**M25 junction 10/A3 Wisley interchange
TR010030**

**9.153 Applicant's Response to
Secretary of State's Letter -
27 November 2020**

9.153 Applicant's Response to Secretary of State's Letter- 27 November 2020

Planning Inspectorate Scheme Reference	TR010030
Application Document Reference	TR010030/9.153
Author:	M25 junction 10/A3 Wisley interchange project team, Highways England and Atkins

Figure 2: Sketch drawing of Option 4 as referred to in Table 1

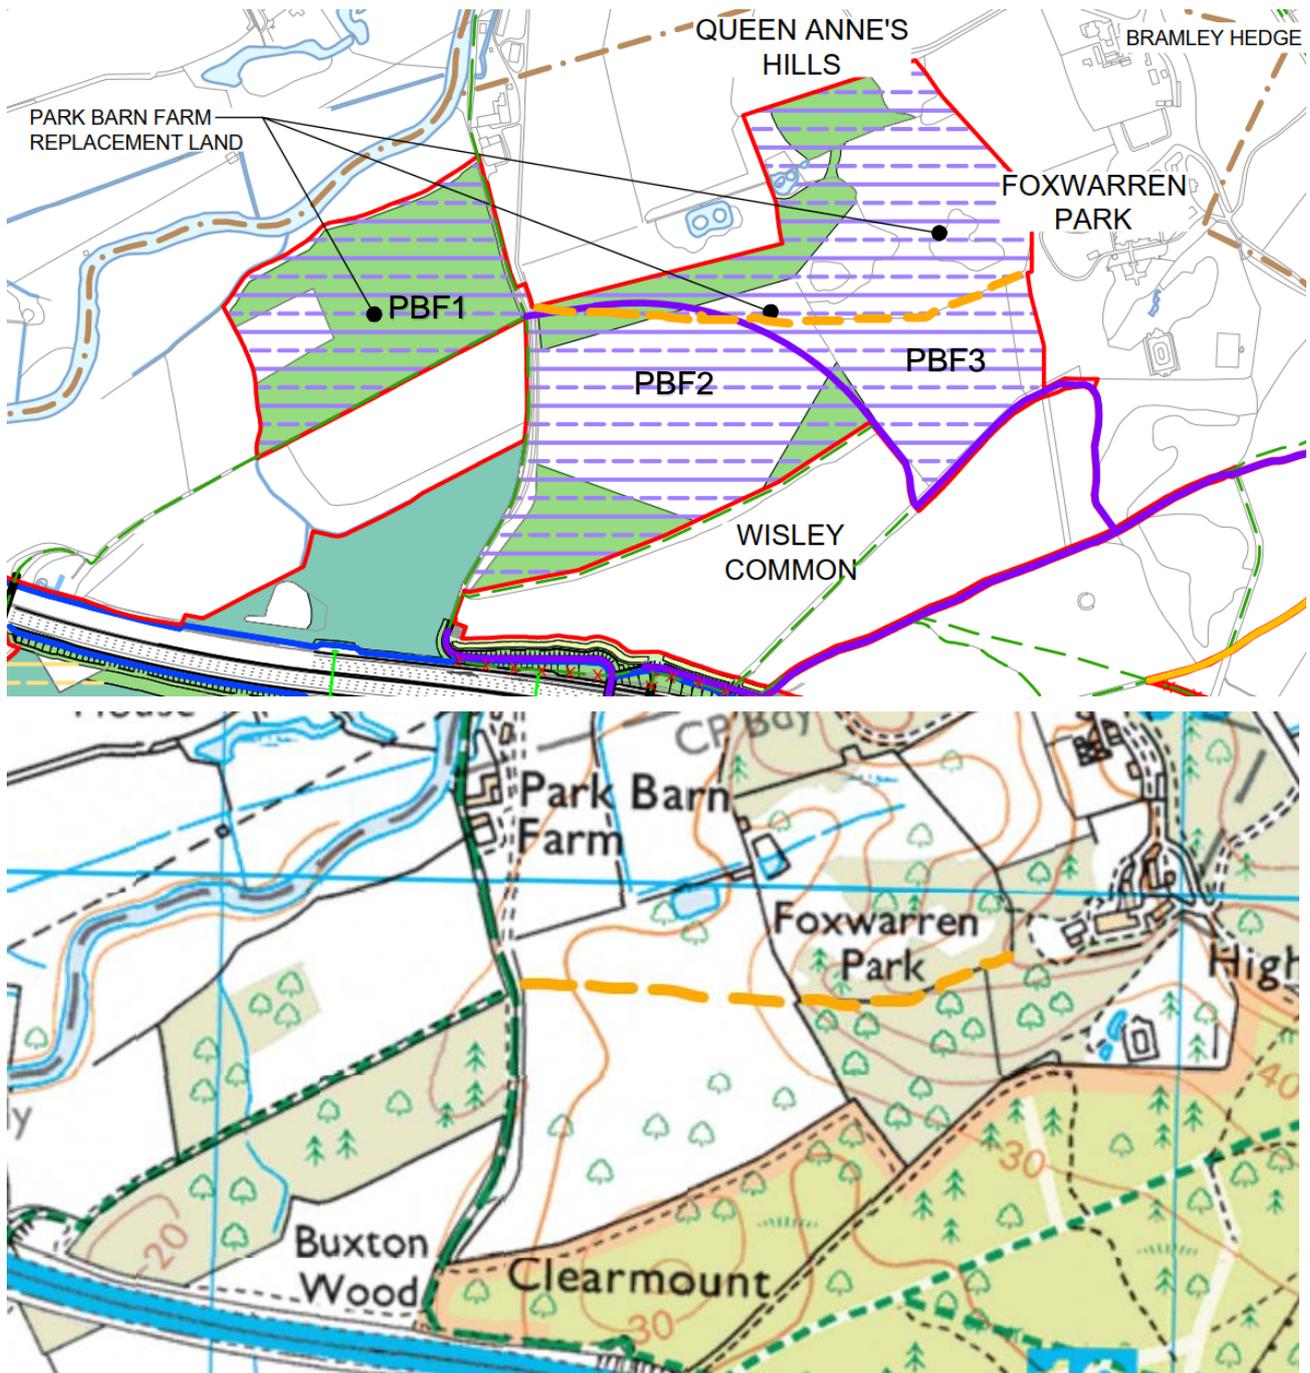
The Secretary of State notes that in response to question 3 of the Secretary of State's consultation letter of 4th November, the applicant has suggested that if the Secretary of State is minded to reduce the replacement land provision, a more suitable proposal would be that the RL provisions in the Order should include:

- *Parcels PBF1, PBF2 and the south part of PBF3 at Park Barn Farm as proposed in the Secretary of State's letter; in addition to the*
- *Areas CF1 and CF2.*

The Secretary of State notes that this proposal would provide a total area of approximately 26.5ha of replacement land, which would equate to ratios of provision of approximately 1.74:1 for acquisition of special category land and 0.31:1 for acquisition of special category (rights) land. The Secretary of State notes it would also enable provision of replacement land for Chatley Heath that is contiguous with existing portions of Chatley Heath. The Secretary of State seeks comments from all interested parties on the above proposal.

- 2.1.1 Highways England wishes to draw the Secretary of State's attention to its comments at 4.6.1 - 4.6.3 and 4.10.4 of its response to his letter dated 4 November 2020, and, in particular, to its comment that the replacement land package to be provided as part of the Scheme would be enhanced by the inclusion of parcel CF3 in addition to CF1 and CF2.
